East Anglia ONE North and East Anglia TWO Offshore Windfarms

Applicants' Comments on Tessa Wojtczak's Deadline 10 Submissions

Document Reference: ExA.AS-17.D11.V1

Date: 7th June 2021

Figure 1 Potential Sensitive Receptors and Areas Subject to Additional Construction Phase Controls

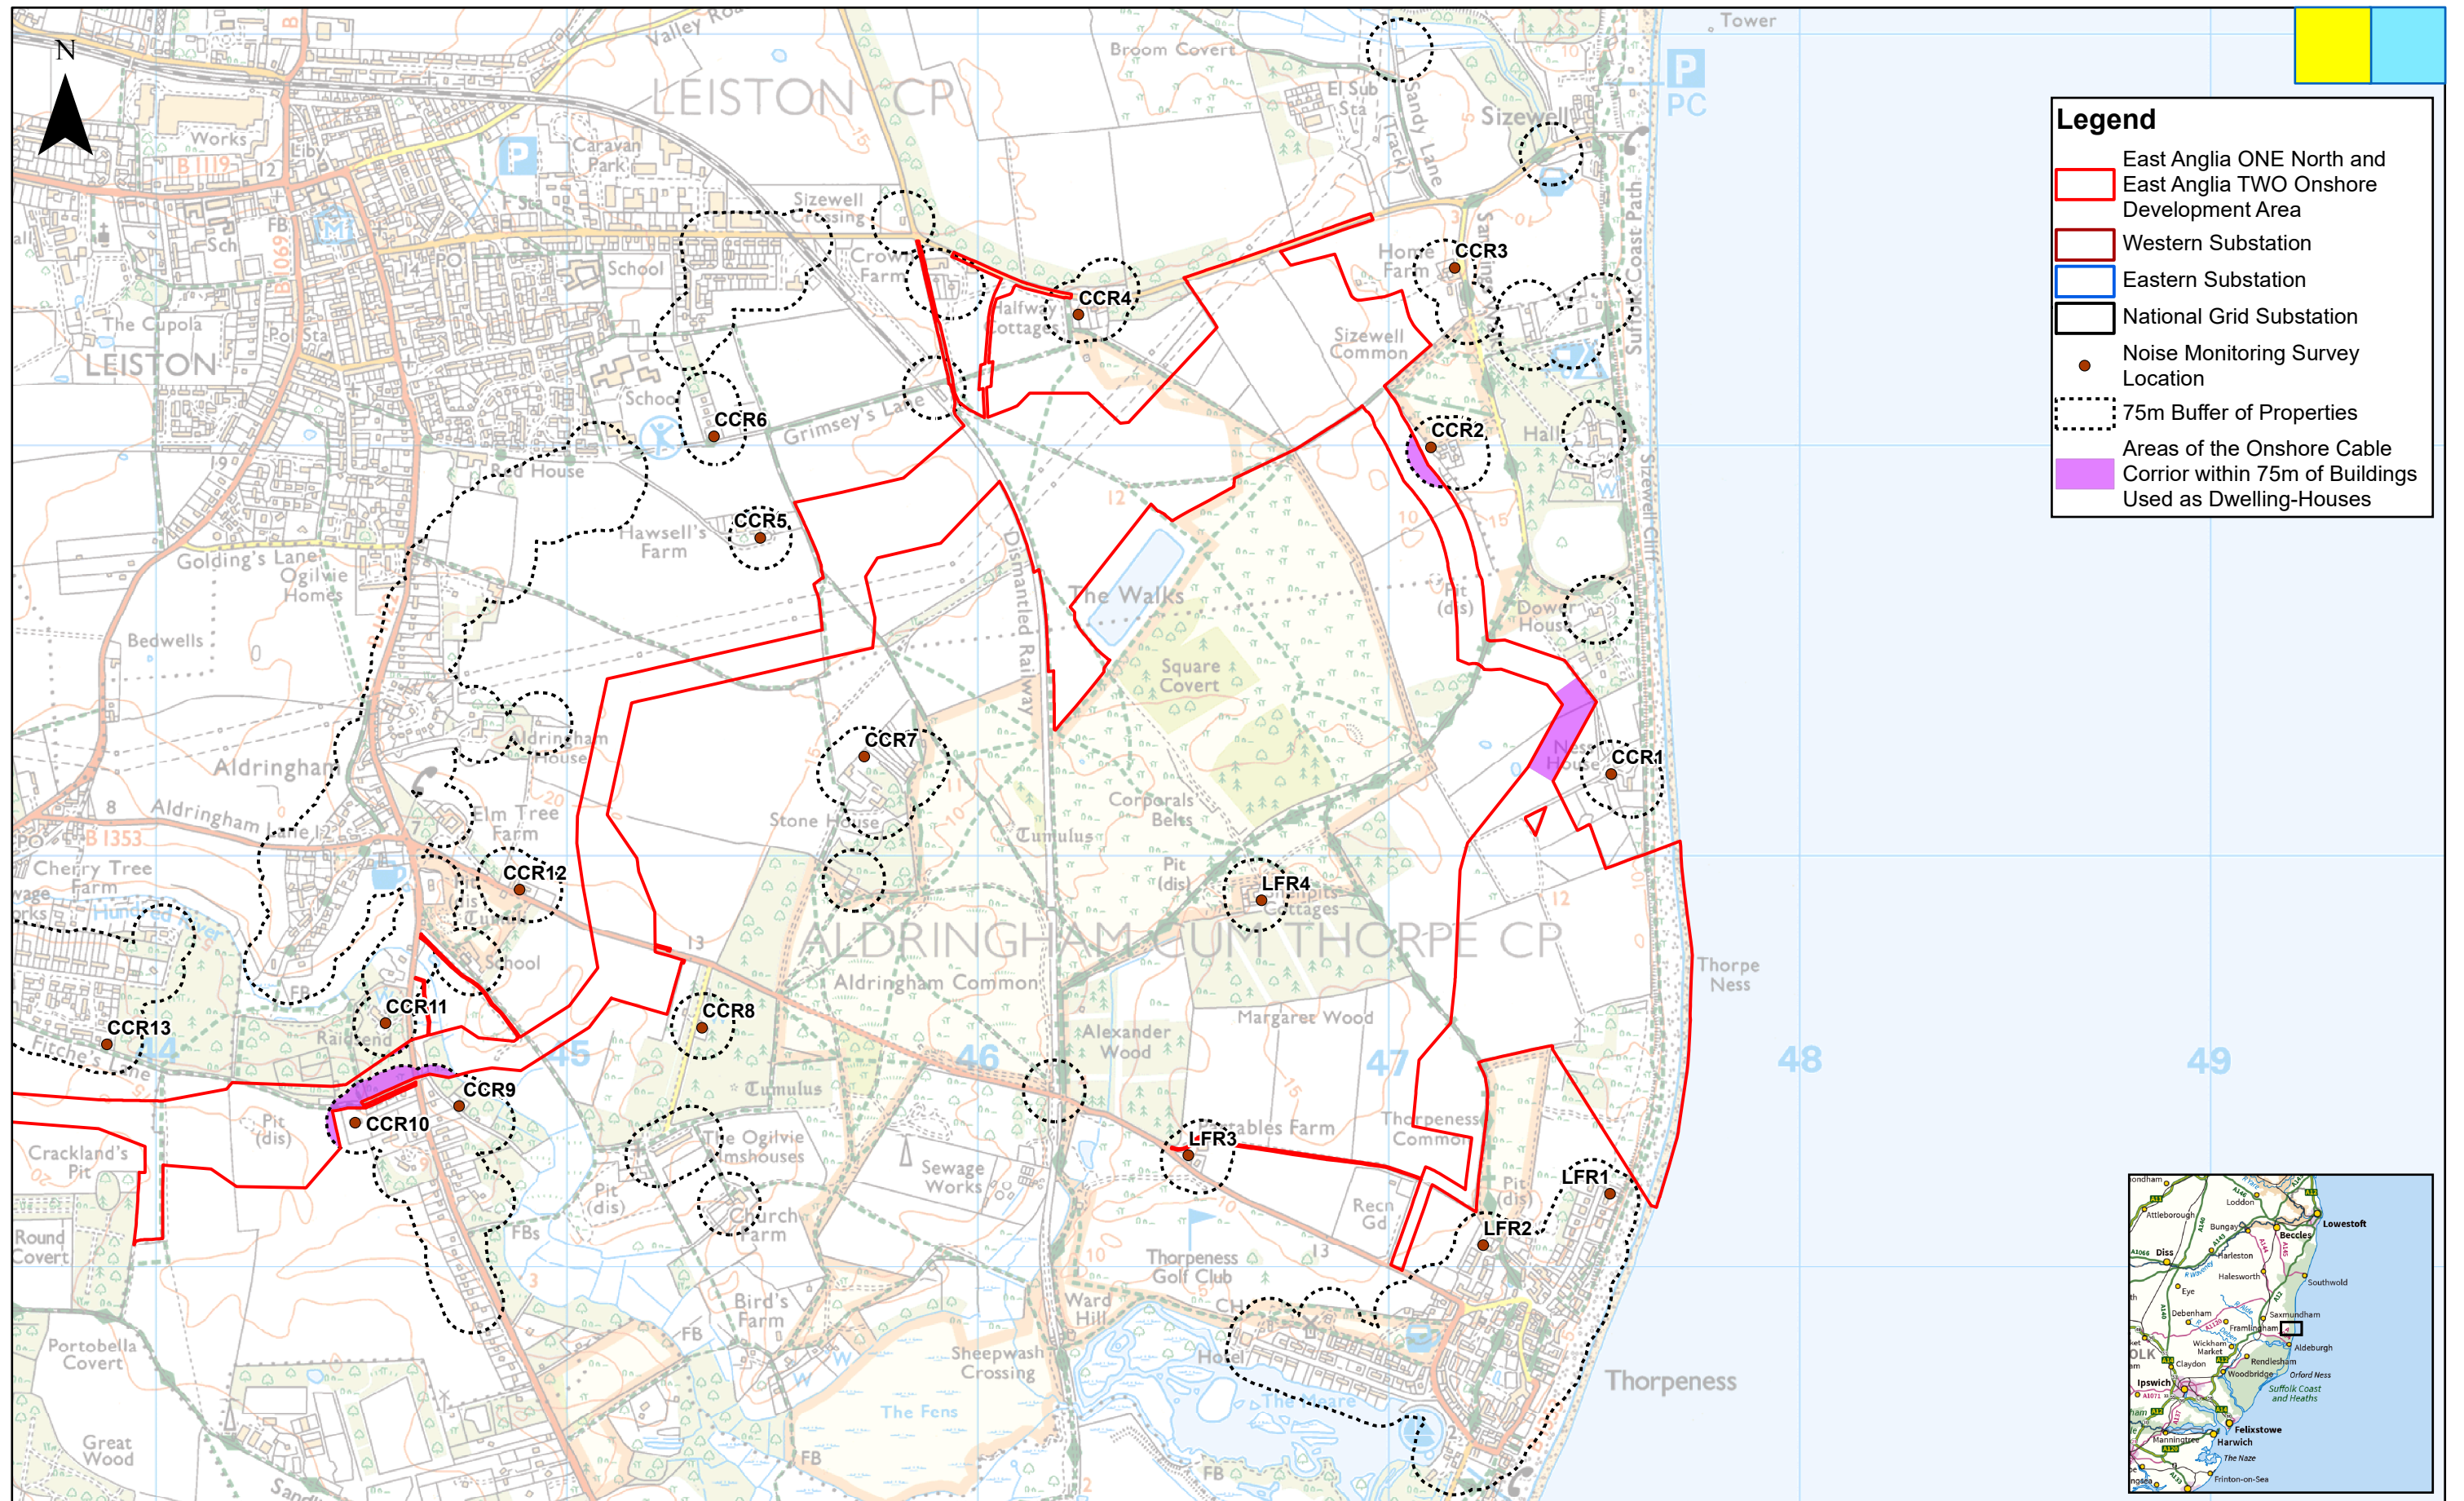
10	<p>2.1.20 In their response here, the Applicants make reference to information on special provision made for this receptor (Wardens Trust) within the Deadline 8 updated Outline CoCP (REP8-017) at Section 9.1.4. Specific Measures at Wardens Trust, including:</p> <p>116. Point 2.</p> <p>“Installation of temporary noise barriers the onshore cable route (sic) which falls within 100 m of the Wardens Hall and the recreational field used by the Wardens Trust charity.”</p> <p>117.” In addition, for the location of onshore cable route in proximity to Wardens Hall, the applicants will reduce the working width of the onshore cable route to 16.1 m per</p>	<p>This is correct. By moving the Order limits away from the boundary of the Wardens Trust property the separation distance between the works and the Wardens Trust premises has increased by a greater distance than that achievable by narrowing the onshore cable route within the previous Order limits. As such, the Applicants have returned to the original onshore cable route width of 32m per Project within the newly aligned Order limits at this location.</p>

ID	Tessa Wojtczak Comment	Applicants' Comments
	<p>project in line with the reduced working with adopted for the crossing of important hedgerows and other features, and construct on the western extent of the order limits.</p> <p>118. The above measures will reduce impacts arising from construction noise as far as practicable during the works undertaken within the vicinity of the Wardens Trust's Wardens Hall and associated amenity field.</p> <p>However, in respect of 117, I note that in the Applicants' Change Request: Order Limits at Work no.9 (Plot 13) (AS-104), at 2.2.3.17, it is stated that:</p> <p><i>“ The Outline CoCP ...will also be updated at Deadline 10 to remove text relating to the reduction of the working width of the Onshore Cable route to 16.1 (per project) when within 100 m of the Wardens Trust property. “</i></p>
